17 April 2019

**Arrangements for Handling Heritage Applications Direction 2015
& T&CP (Development Management Procedure) (England) Order 2015
& Planning (Listed Buildings & Conservation Areas) Regulations 1990**

**LAND TO THE NORTH OF CASTLE STREET AND SOUTH EAST OF
WATERHOUSE LANE INCLUDING CASTLE BUILDINGS AND THE EARL DE
GREY PUBLIC HOUSE, KINGSTON UPON HULL, HU1 2DA
Application Nos 19/00334/LBC & 19/00333/FULL**

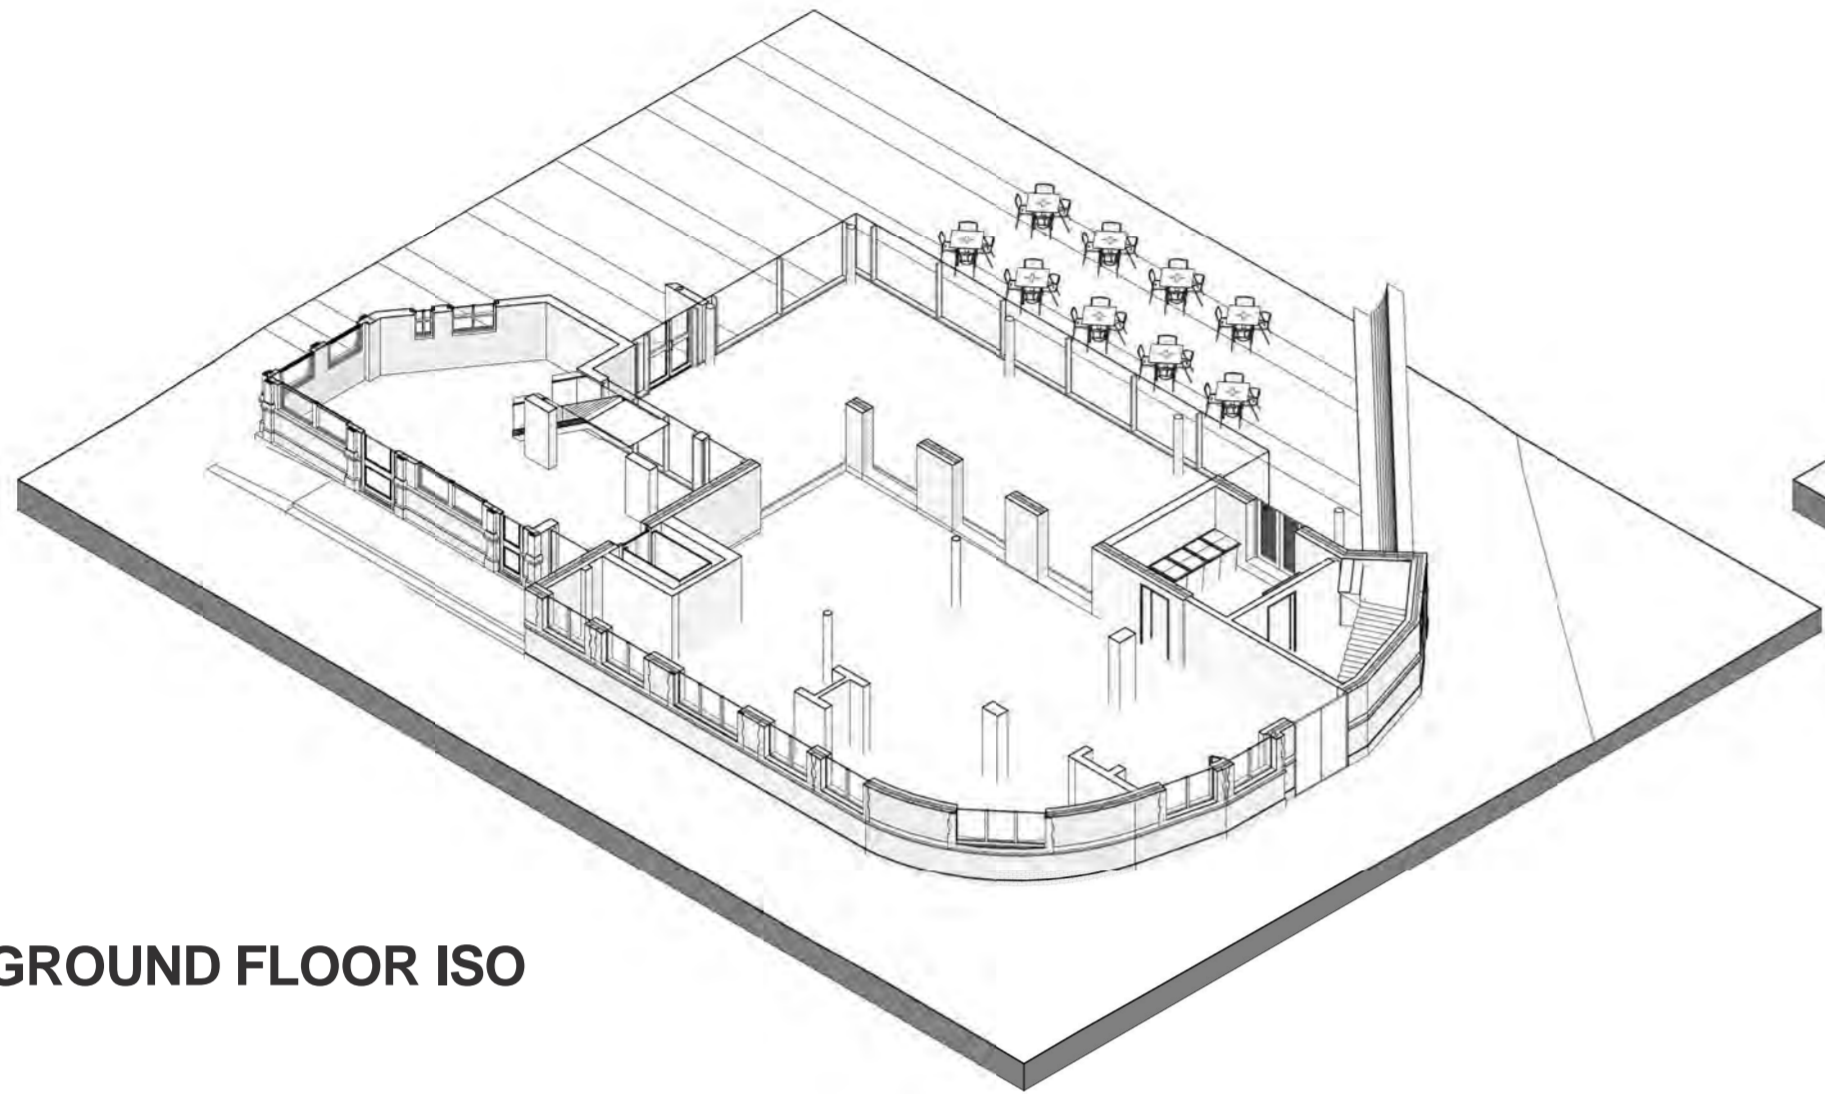
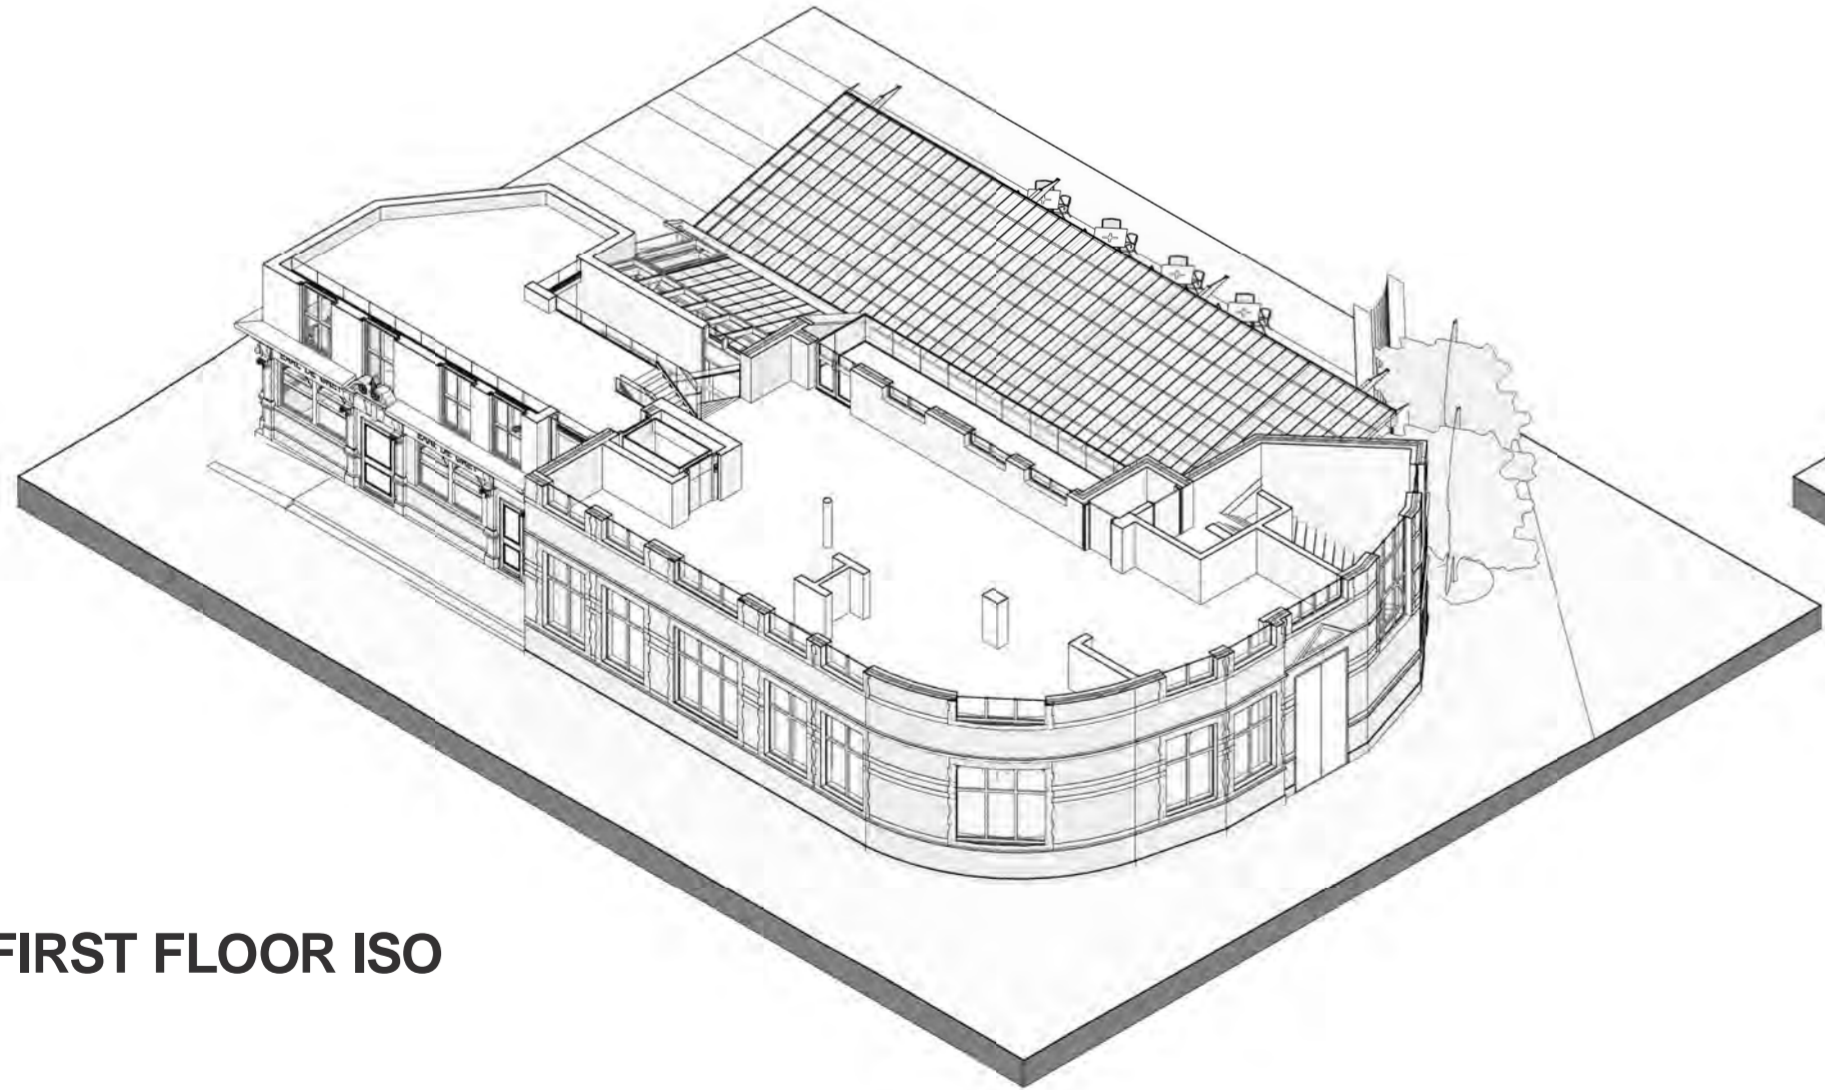
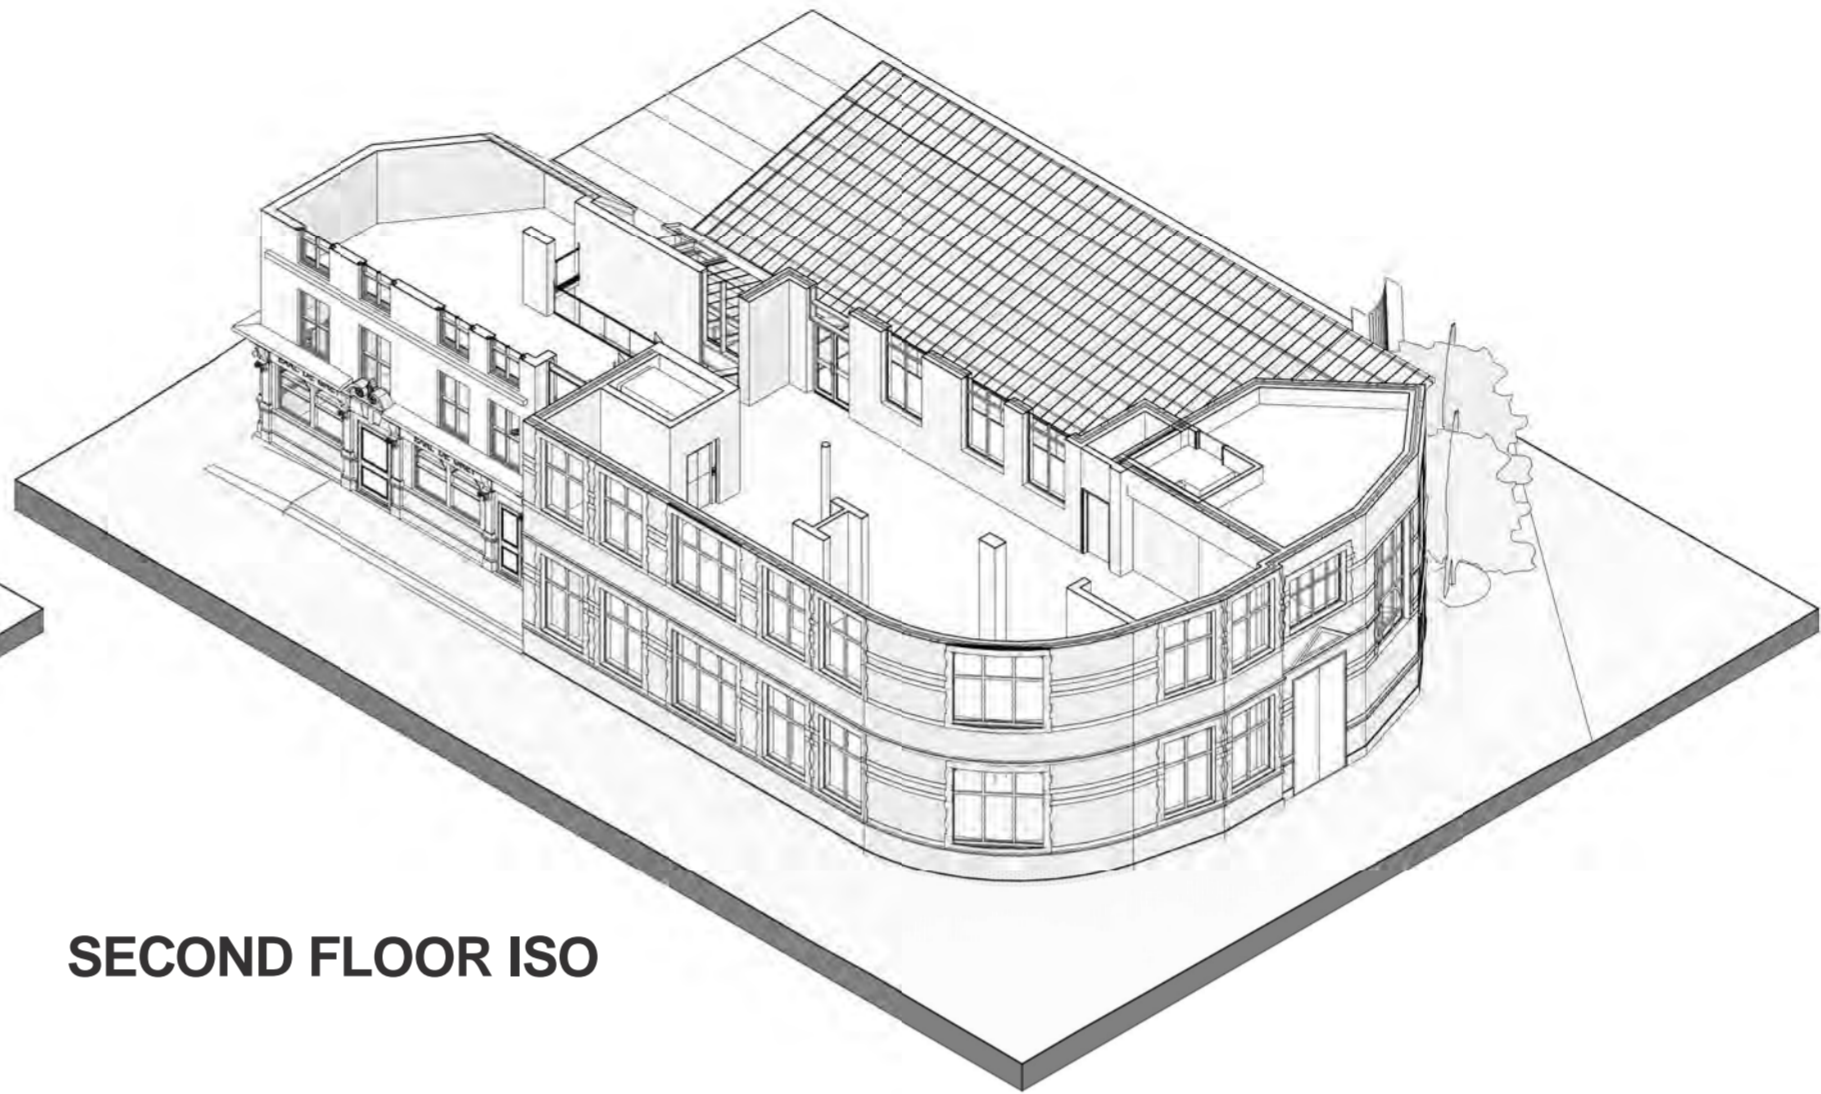
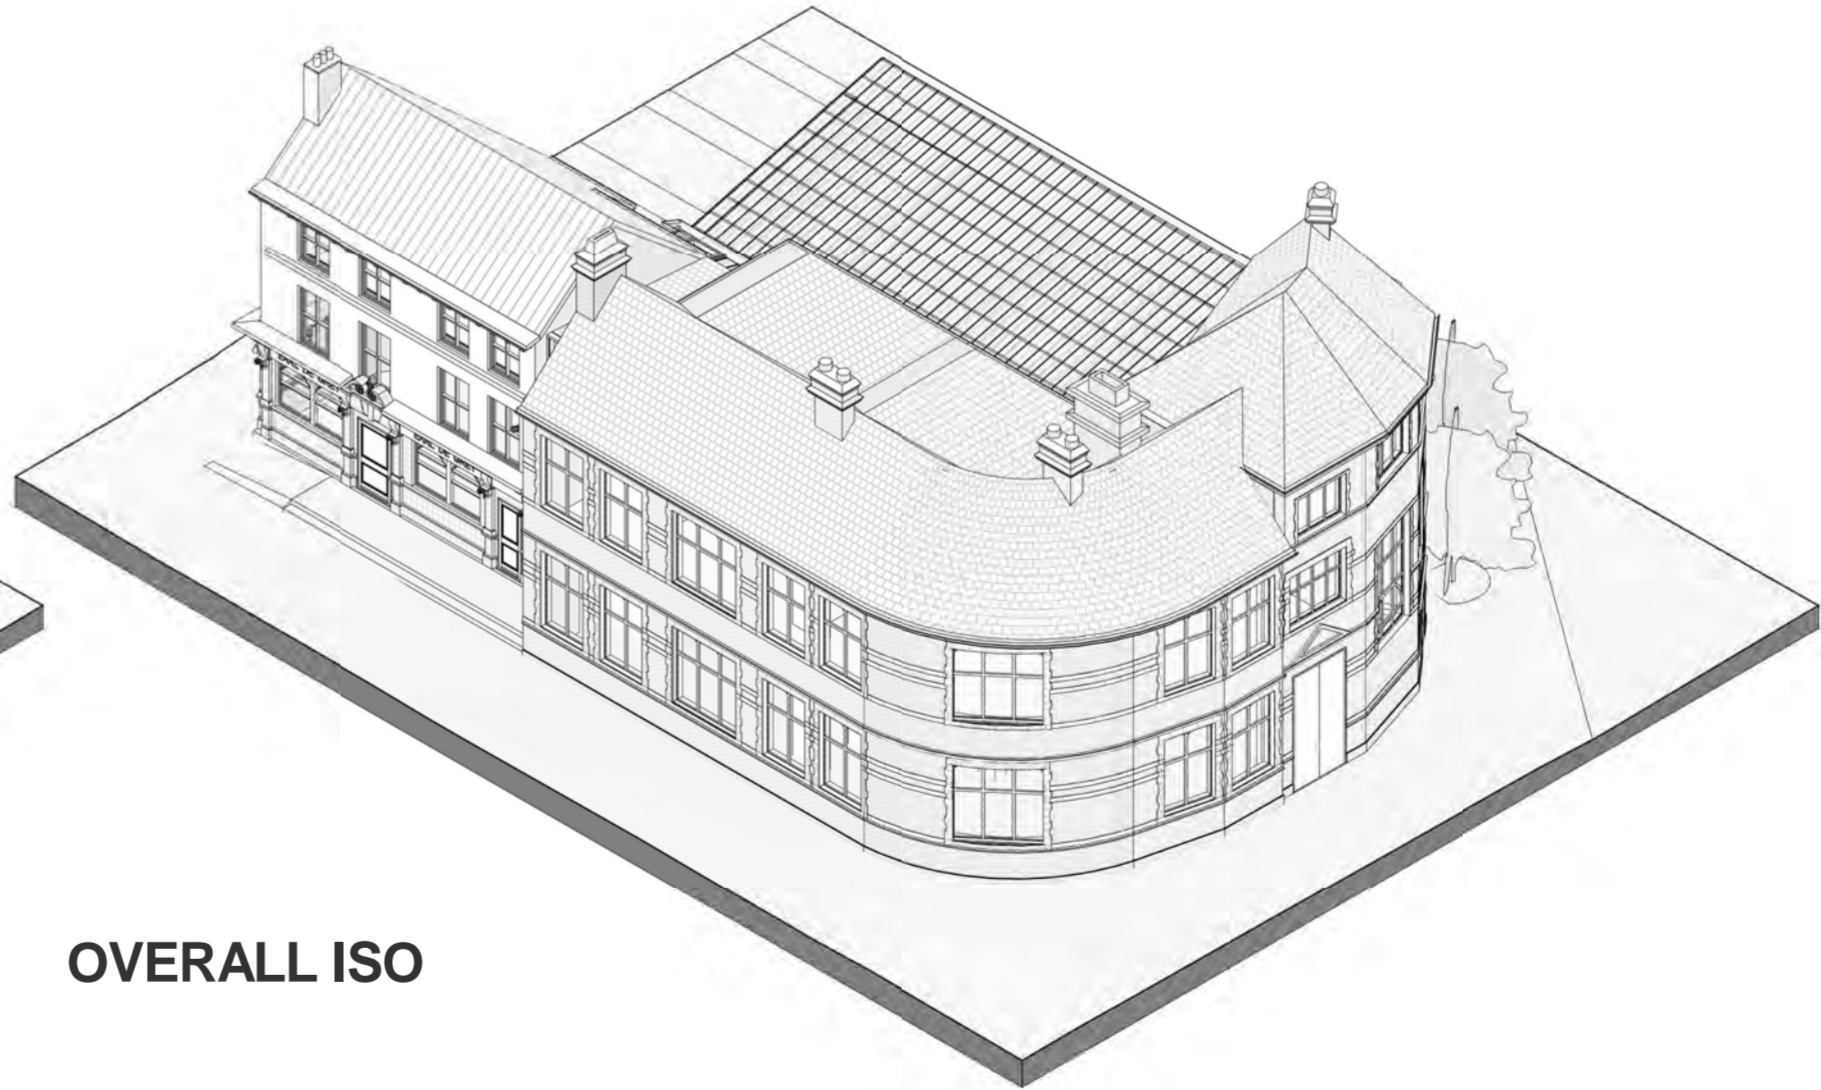
- The proposed elevations should be revisited so that the fenestration matches the existing, including the proportions of the chimney stack.

- The new main entrance doors should be double doors to a traditional design.
